Office of  
Environment  
& Heritage

DOC17/477236  
SSD 8344

**Notice of Exhibition - North Kellyville Public School, 120-126 Hezlett Road, Kellyville (SSD 8344)**

## ATTACHMENT 1 – Office of Environment and Heritage comments

Image 1 – Photo taken from north/dam side of tree, showing shale beneath the root buttress of the tree

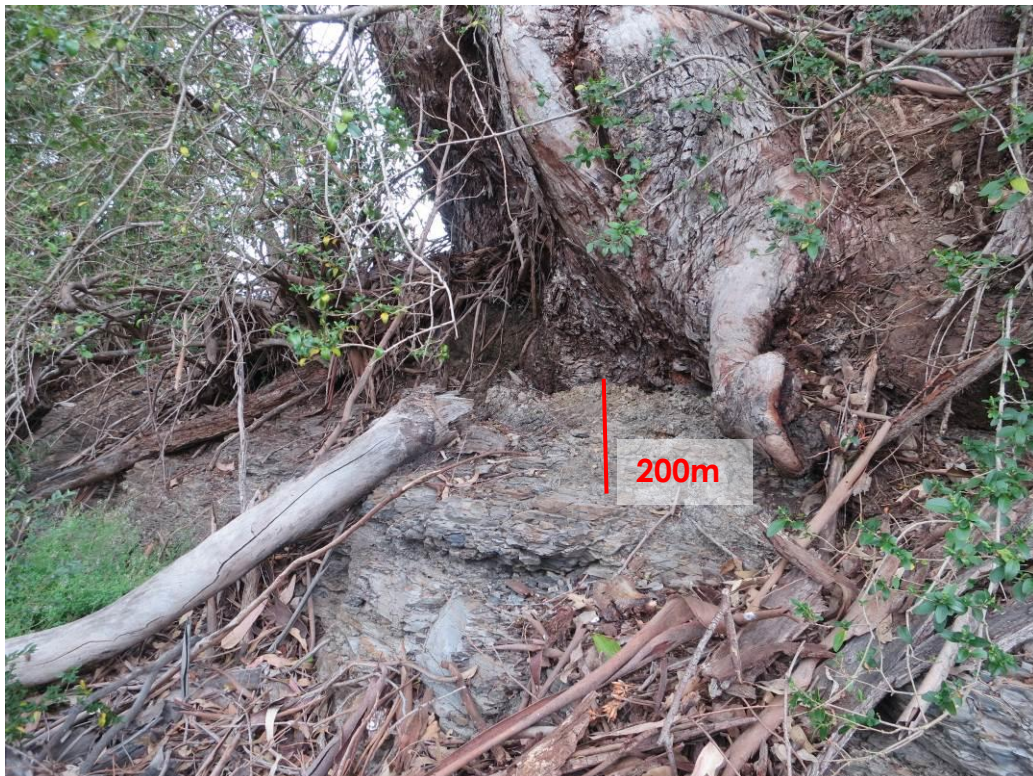
OEH supports the proposal in the Pre Development Tree Audit prepared by Arboreport (25 May 2017) to retain the multi-trunked *Eucalyptus tereticornis* located near the existing onsite dam. However, this tree may be impacted by the earthworks within the 22.4m development exclusion zone associated with filling in the dam and level the site for a play area. The Audit does not comment on whether the tree is a hollow bearing tree (HBT) or whether it is likely to support any native fauna species.

OEH recommends that the tree be surveyed for hollows and that its viability be reassessed. If it is a HBT and it is determined that viability of this tree in the long term is low, it is recommended that a condition be imposed requiring an artificial hollow replacement strategy be developed consistent with the Tree Management Plan requirements of the North Kellyville Development Control Plan (DPE, November 2016, page 35).
